**Our ref:** 26\_34247\_P

**Your ref:** H06-1292-25

**Site Location:** Land at Green Lane Holbech St  
Johns Spalding Lincolnshire

**Summary of Proposal:** Erection of Agricultural  
Dwelling - outline approval H06-0101-24

Site Plan
Scale: 1:200

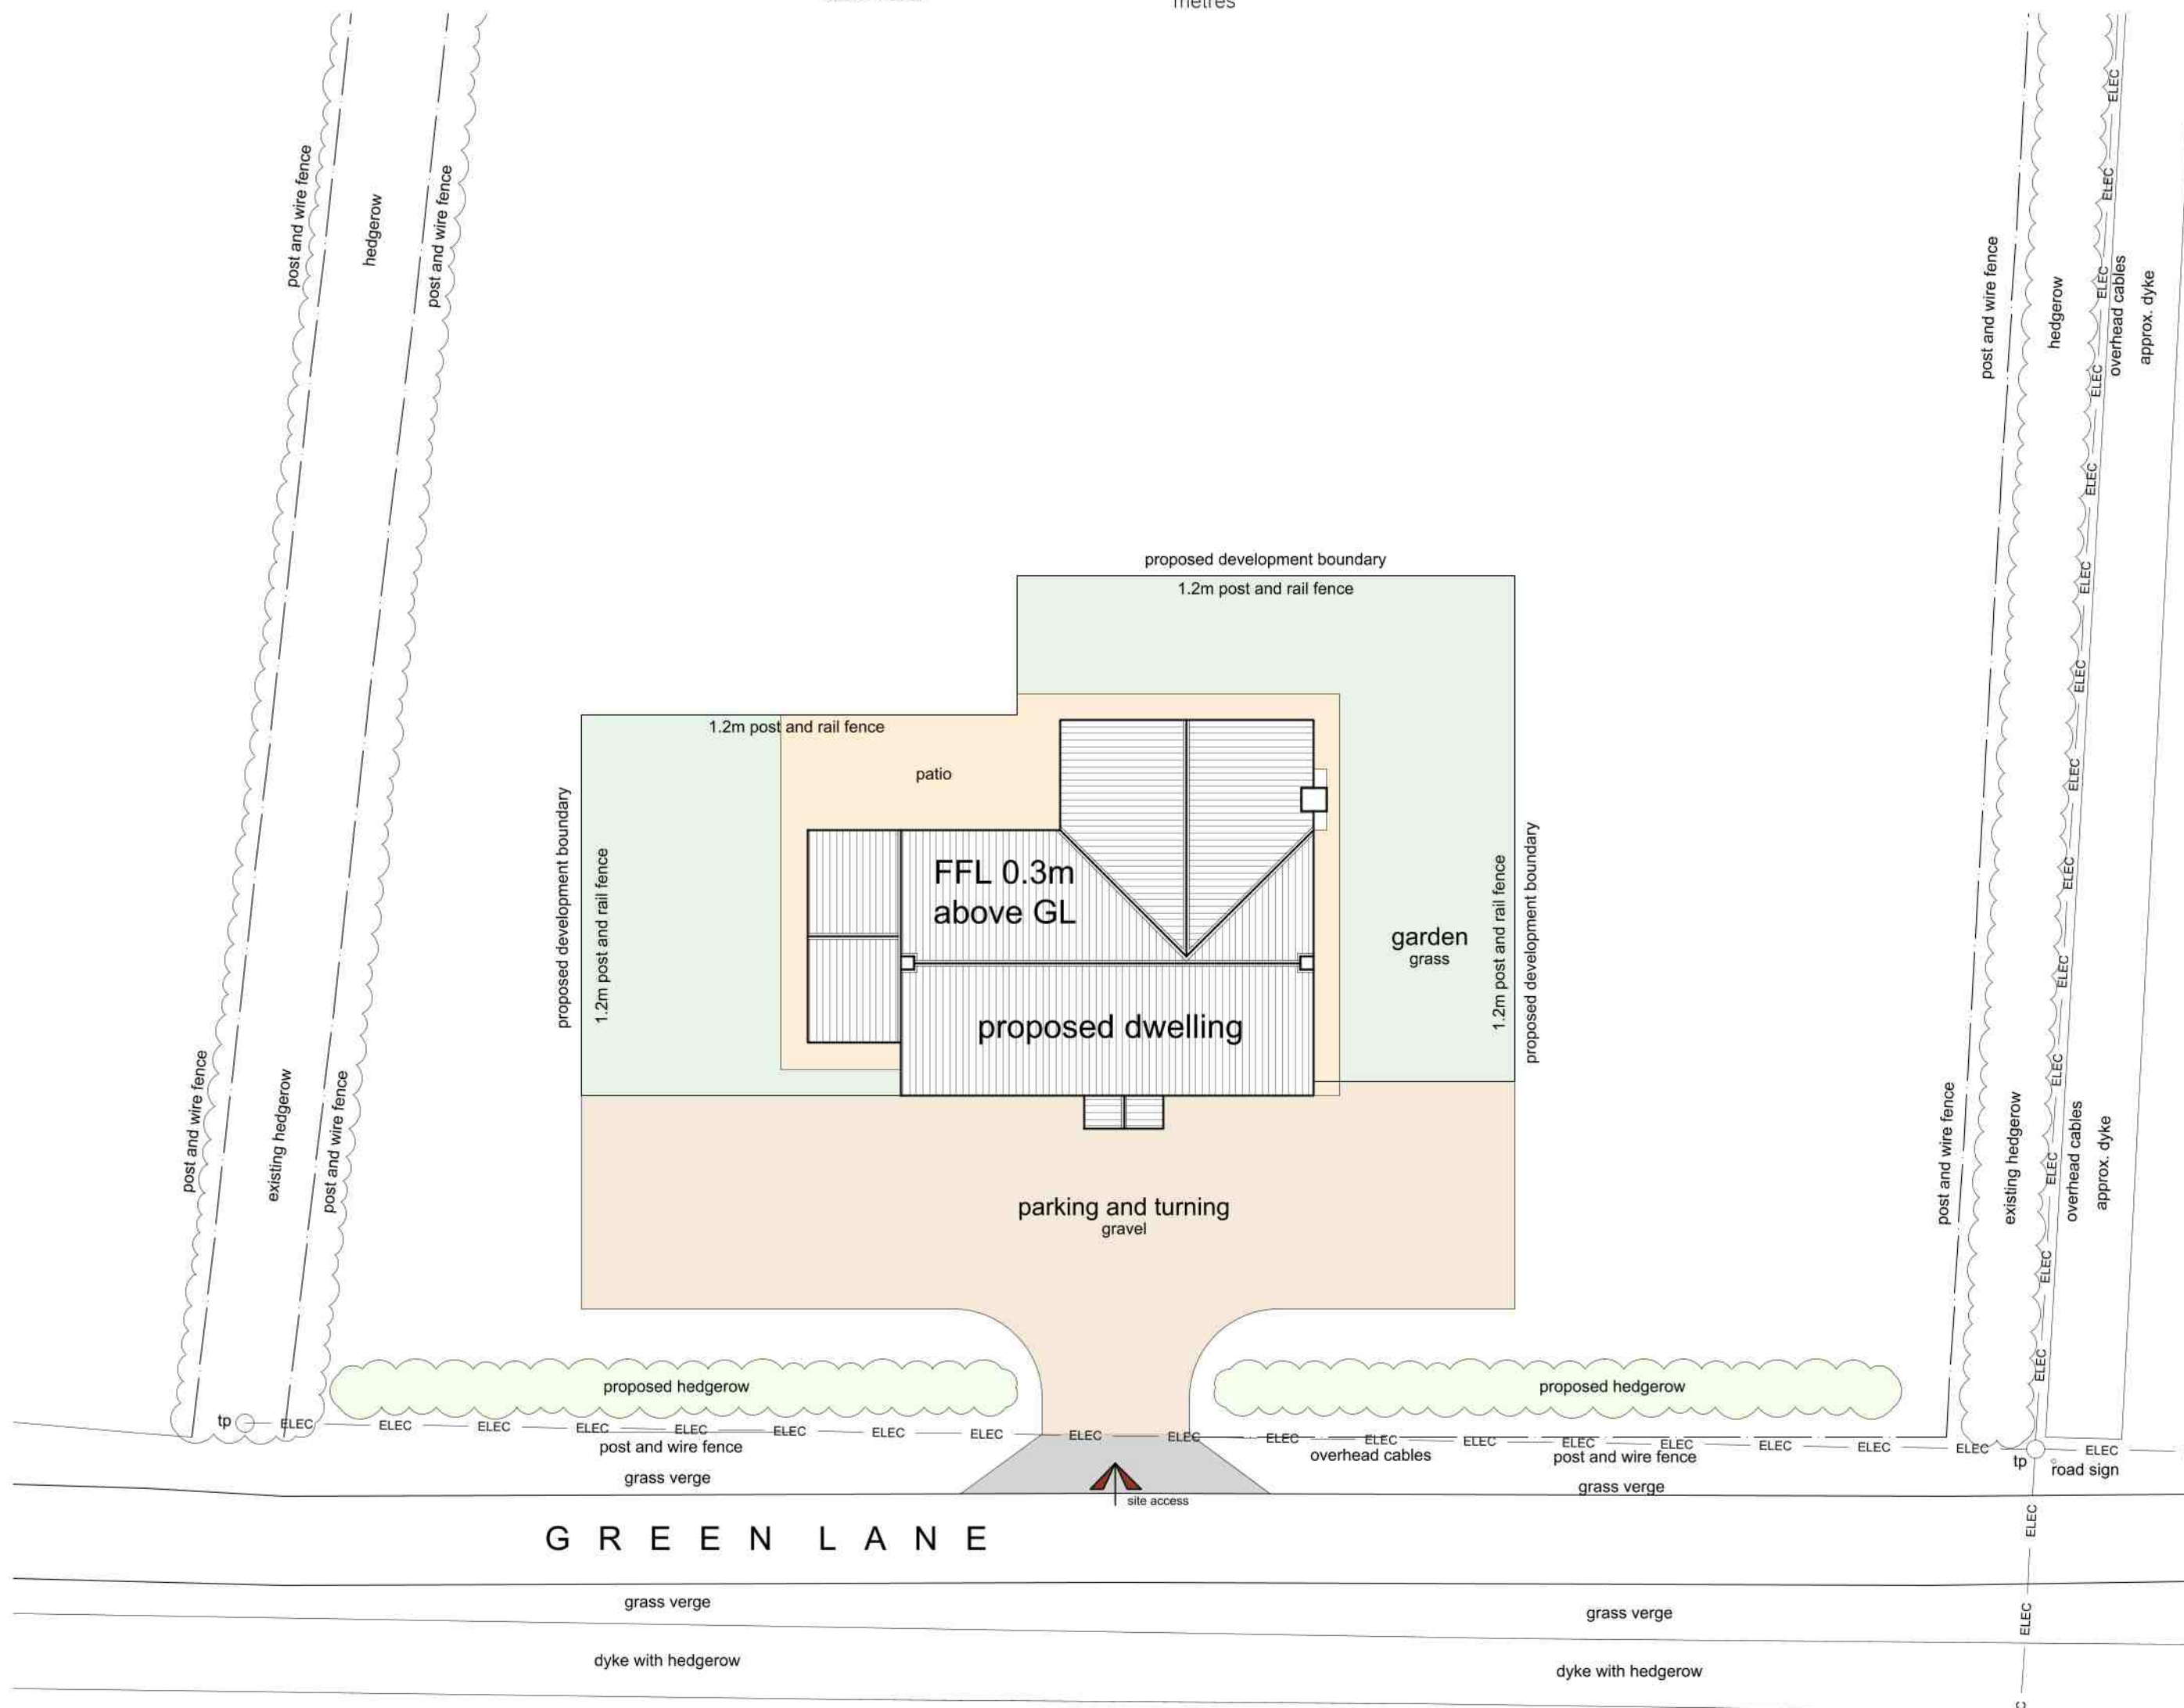
I cannot see that the applicant has identified a drainage strategy for the site within their application. We recommend a drainage strategy is provided for the site. If the applicant proposes to discharge surface water to a watercourse, consent would be required under Byelaw 3.

I note that the applicant has not indicated how they propose to dispose of foul water from the development. If the applicant proposes to discharge treated foul water to a watercourse, consent would be required under Byelaw 3. Please note that any consent granted for the discharge of treated foul water is likely to be subject to a Treated Foul Water Development Contribution fee (TFWDC) as outlined within our [Development Control Charges and Fees](#).

I note the presence of a watercourse which is not maintained by the Board (a riparian watercourse) adjacent to the northern and southern site boundaries. Whilst not currently proposed, should the applicant's proposals change to include works to alter the riparian watercourse, or if works are proposed to alter the watercourse at any time in the future, consent would be required under the Land Drainage Act 1991 (and Byelaw 4).

I note the presence of a Board arterial watercourse F34 Hines Drain (DRN197P3401) adjacent to the wider site boundary. Whilst not currently proposed, should the applicant's proposals change to include works to alter the watercourse, or if works are proposed to alter the watercourse at any time in the future, consent would be required under the Land Drainage Act 1991 (and Byelaw 4).
